Item No. **Report of the Head of Planning, Sport and Green Spaces**

Address 63 BRIDLE ROAD EASTCOTE

Development: Two storey side extension, single storey rear extension and infill extension to entrance

LBH Ref Nos: **69386/APP/2014/3021**

SITE PLAN

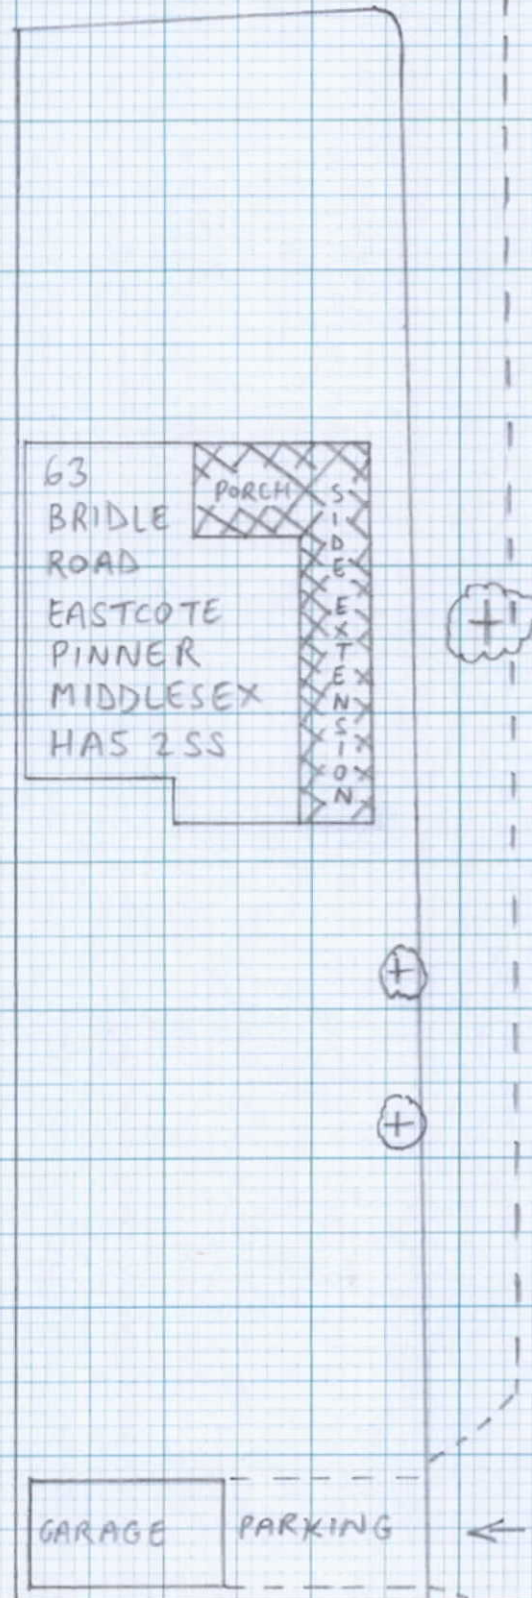
The appeal decision however, also identified that whilst a gap of 1m to the boundary would comply with HDAS, the proposed side extension would significantly erode the existing space to the side of the property. It was considered therefore that the proposed extension would detract from the open character of the road junction to the detriment of the street scene. Consequently the erosion of this space, together with the loss of some of the distinctive features of the building would combine to significantly detract from the importance and positive contribution that the property makes to the streetscene. The Inspector commented as follows:

Given that the space to the side is still being eroded the proposal is considered unacceptable and contrary to Policies BE13, BE15 and BE19 of the Hillingdon Local Plan: Part Two - Saved UDP Policies (November 2012) and Section 5 of the SPD HDAS: Residential Extensions.

PROPOSED GROUND FLOOR PLAN

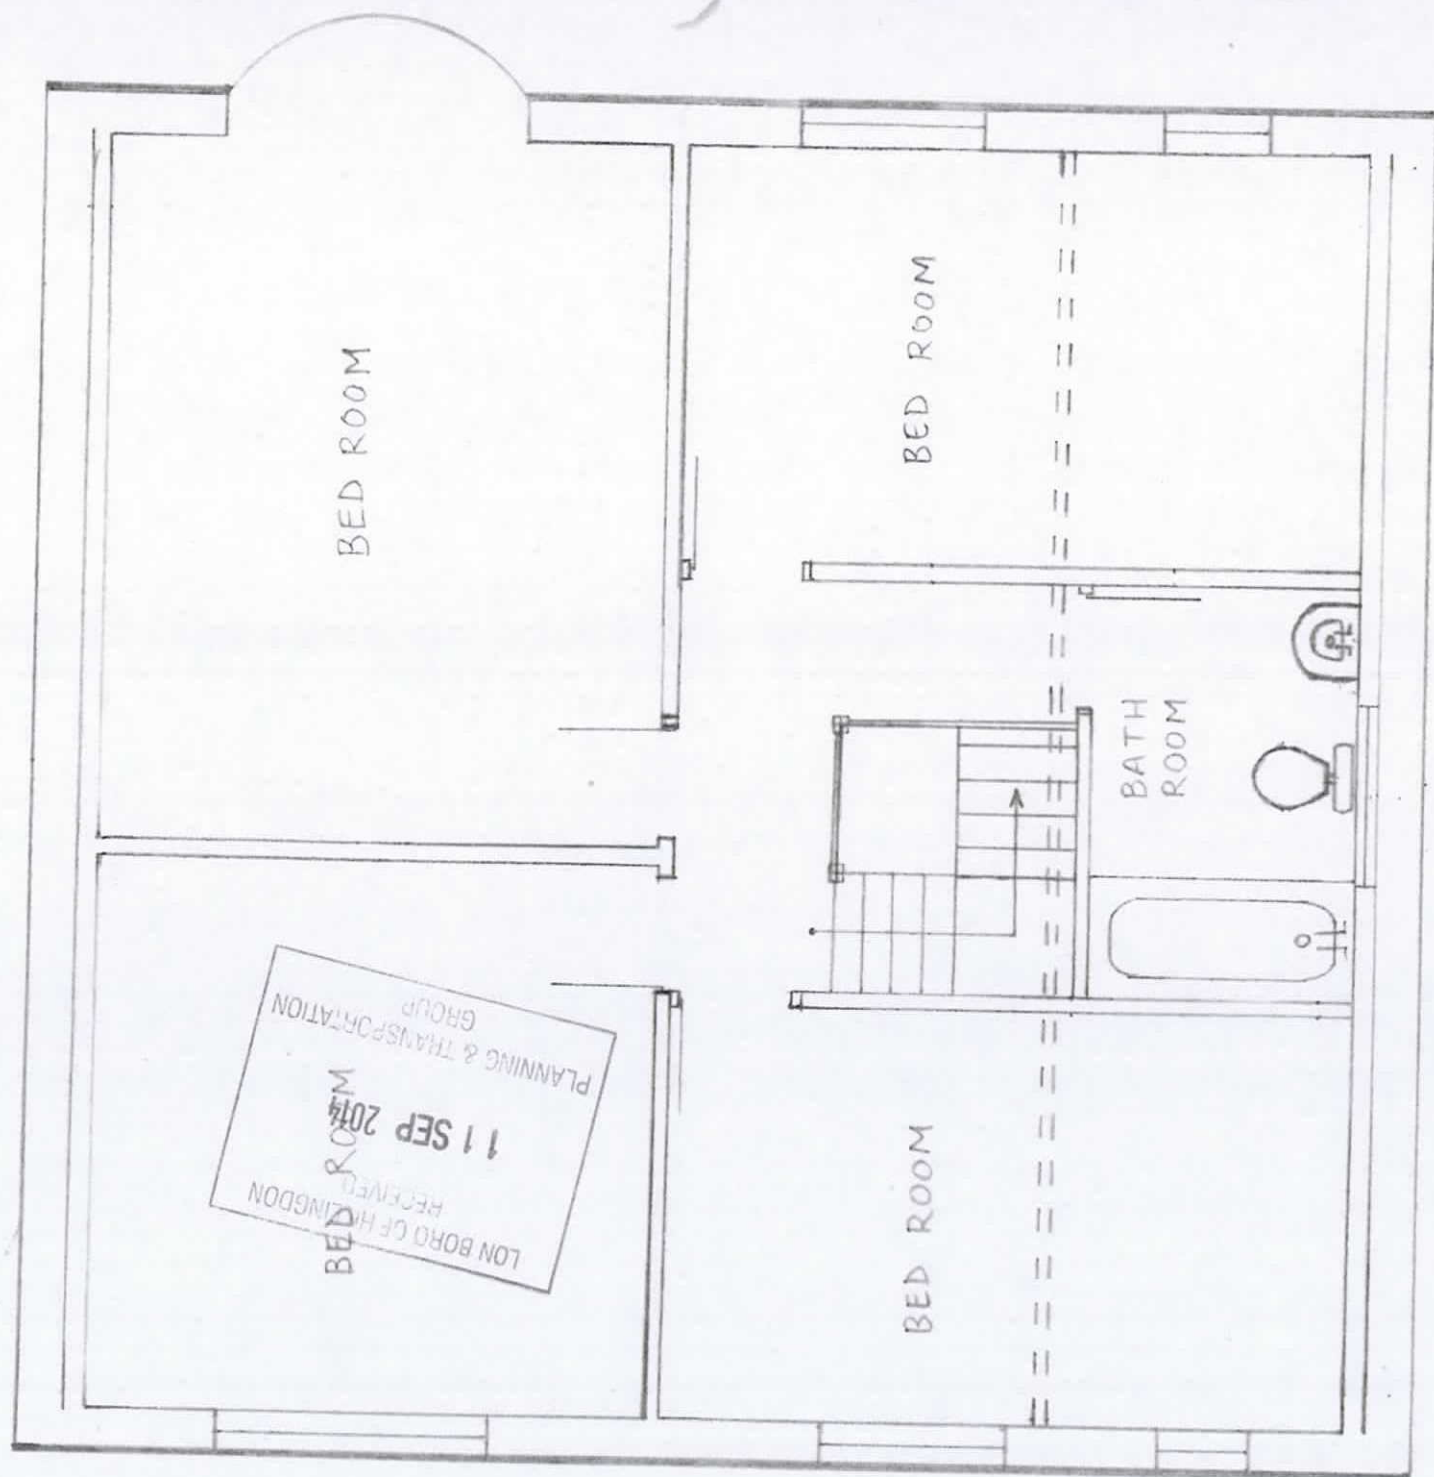
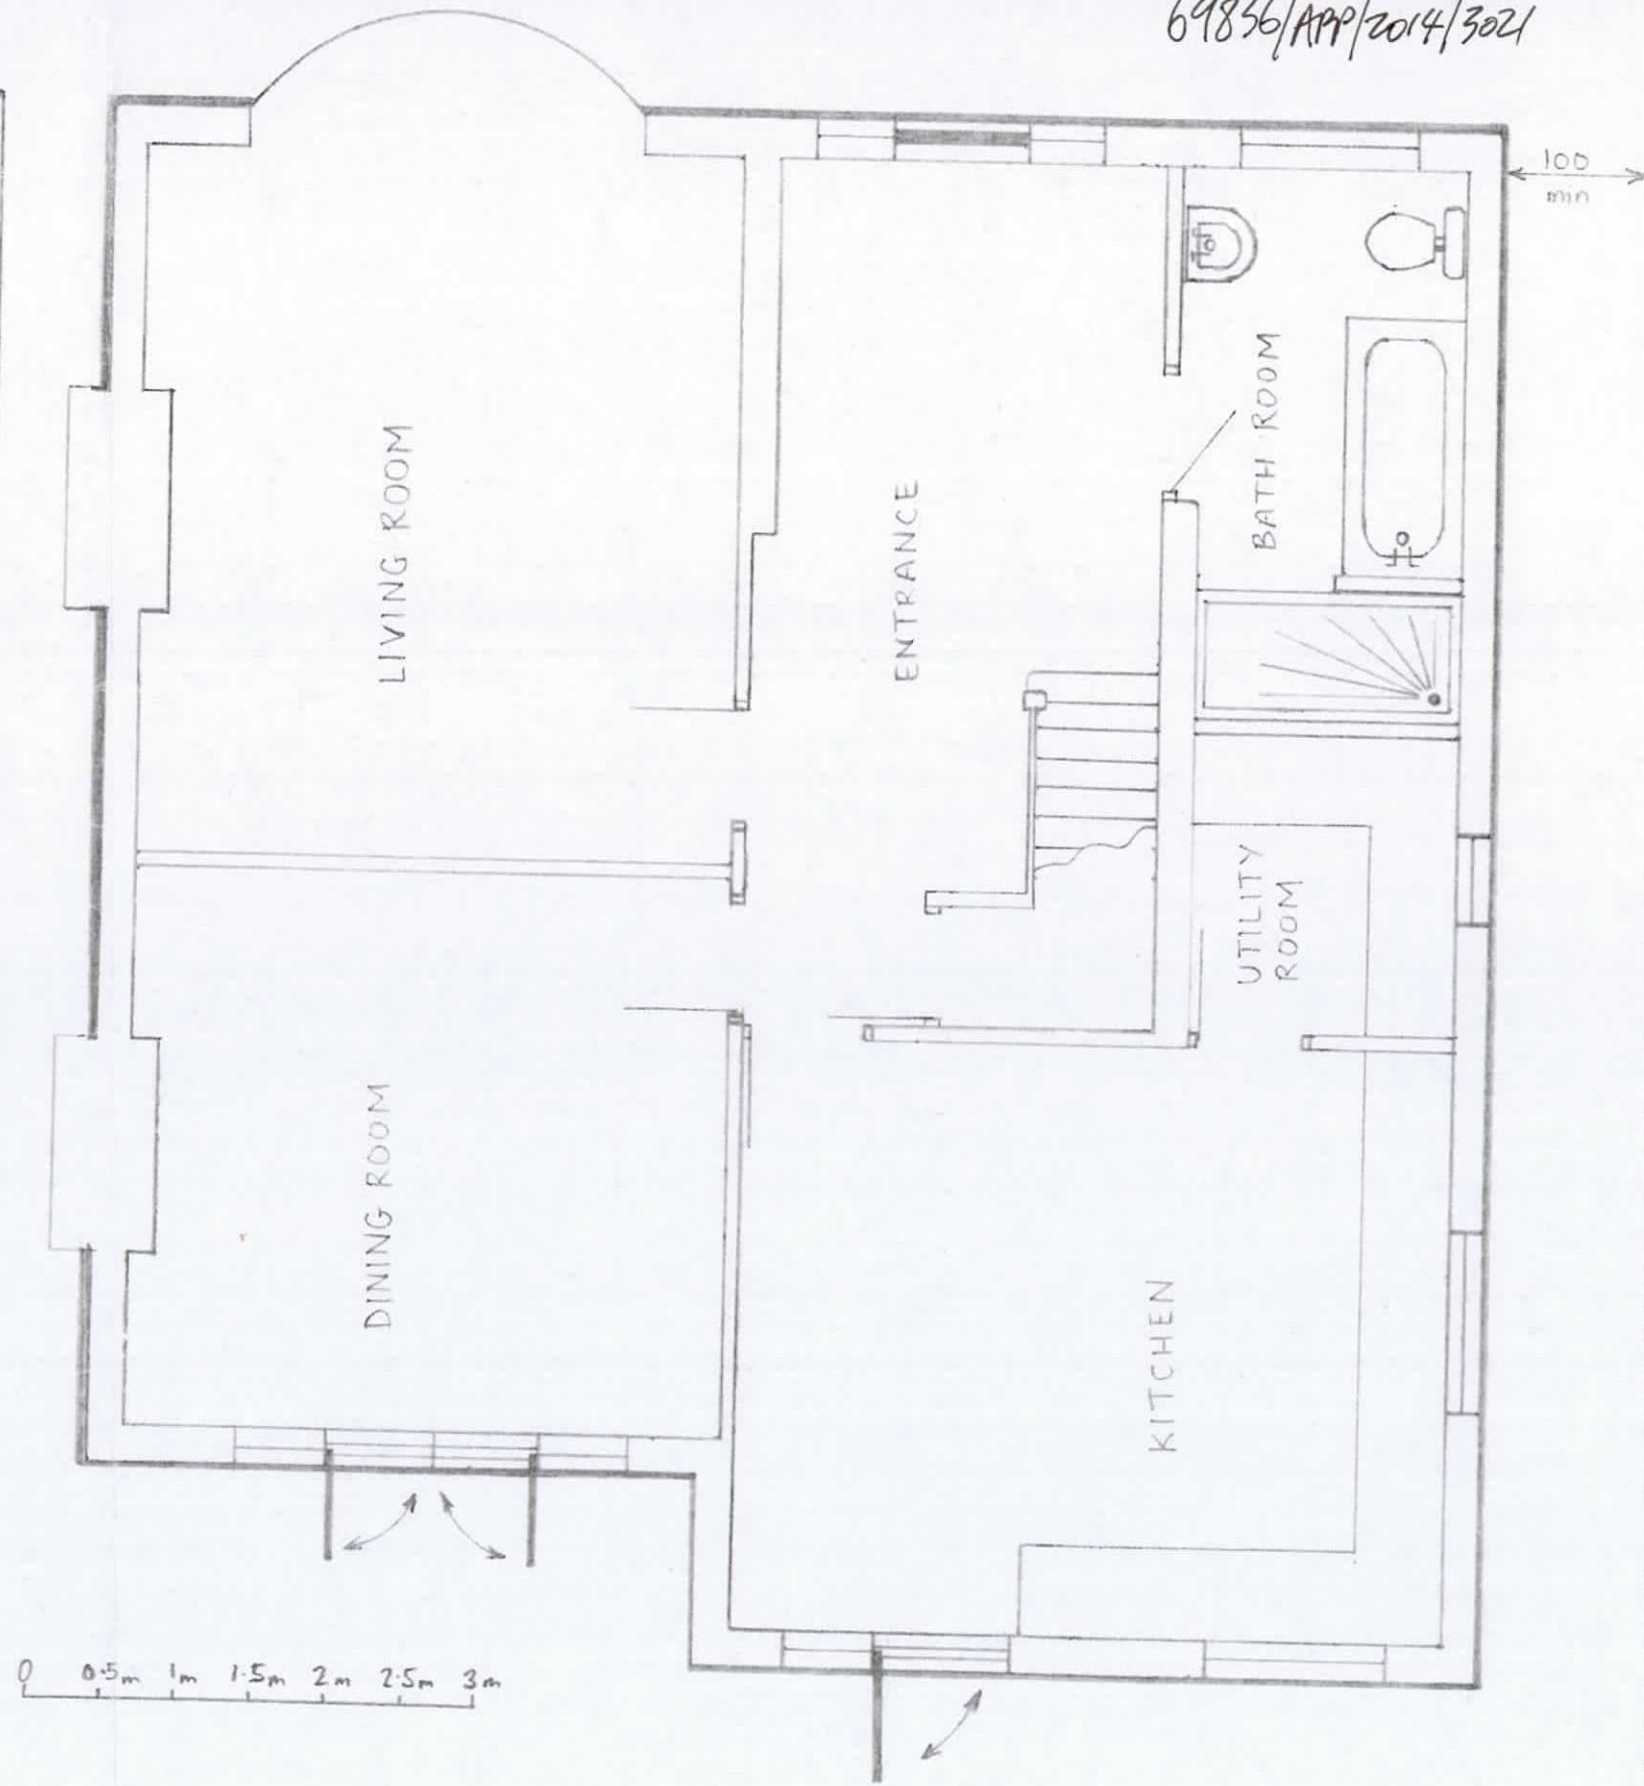
The proposed two storey side extension measures 10.4m in length at ground floor level, including a 1.3m projection beyond the rear elevation of the existing dwelling. The single storey rear extension, measures 2.45m wide and has a flat roof measuring 3m high. The first floor element of the proposal measures 9.1m long and runs the full length of the existing dwelling. It also measures 2.45m wide, adjoins the existing roof at 7.7m high at the ridge and 5.4m at the eaves. It is 1m from boundary of the site.

The appeal decision also raised concern that the side extension would result in the infilling of the recess to the front elevation, and would result in the loss of this distinctive feature of the property and thus this element of the proposal and its impact on the character of the property is considered unacceptable.

The proposed side extension, by virtue of its position and siting would result in the loss of the distinctive front open porch feature and would thus be detrimental to the appearance of the original house, the visual amenities of the street scene and the character and appearance of the wider area. The proposal would therefore be contrary to policies BE13, BE15 and BE19 of Hillingdon Local Plan: Part Two - UDP Saved Policies (November 2012) and The Council's adopted Supplementary Planning Document HDAS: Residential Extensions.

SIDE ELEVATION

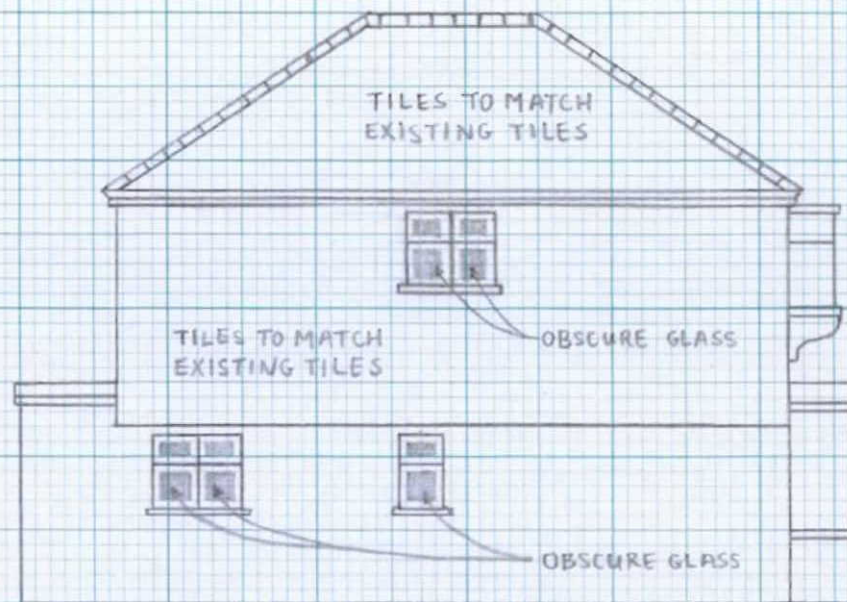
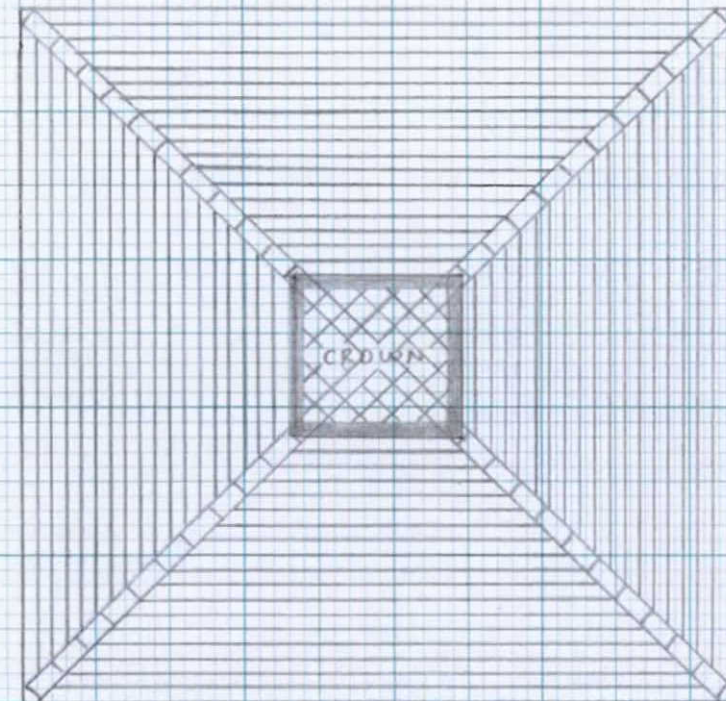
The previous proposal raised concerns over changes to the roof design to the existing dwelling. This proposal has amended the design to retain the distinctive barn-hip shape over the extension. Furthermore the two storey element of the side extension has moved forward so the front is level with the existing dwelling, but has removed the rear projection, which was raised as a concern by the Planning Inspector.

The proposed side extension by reason of its size, scale, height, bulk and prominent siting in this open prominent position would result in the closing of an important gap characteristic to the area, resulting in a cramped appearance and would result in an incongruous addition which would detract from the visual amenities of the street scene and the wider area. The proposal is therefore contrary to Policy BE1 of Hillingdon Local Plan: Part One - Strategic Policies (November 2012), Policies BE13, BE15 and BE19 of Hillingdon Local Plan: Part Two - UDP Saved Policies (November 2012) and The Council's adopted Supplementary Planning Document HDAS: Residential Extensions.
